Online Comment

Application H23-0062-20
Location CORNER HOUSE CHURCHGATE WHAPLODE PE12 6TA
Proposal Details of scheme to deal with contamination (Condition 7 of H23-0095-19)

I have reviewed the Humberside Materials Laboratory Limited report' Phase 1 (desk study) report Corner House, Church Gate, Whaplode' Report no 991/4873/P/P1 Rev 0 dated June 2019 and make the following comments:

Drawing Title: Borehole location plan

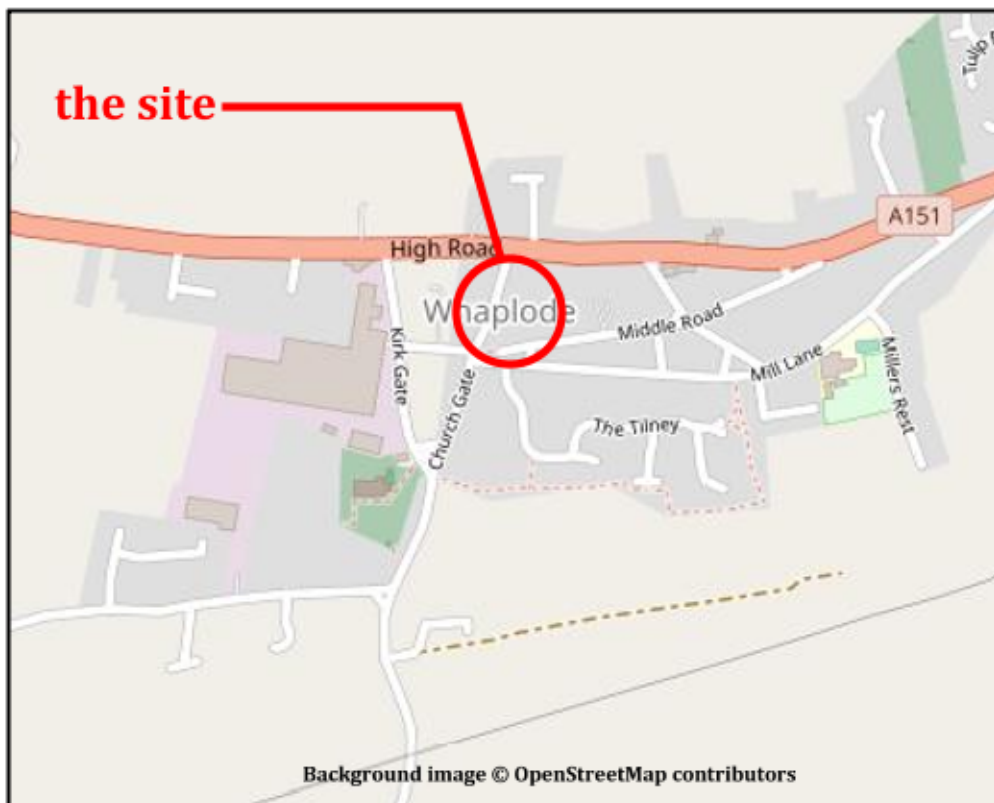
I am in agreement with the findings of the report in that site investigation is required, however I feel that the proposed scope of works is a bit too limited. I would like to see the option for four exploratory locations rather than just two, as there is the potential for varied ground conditions across the site.
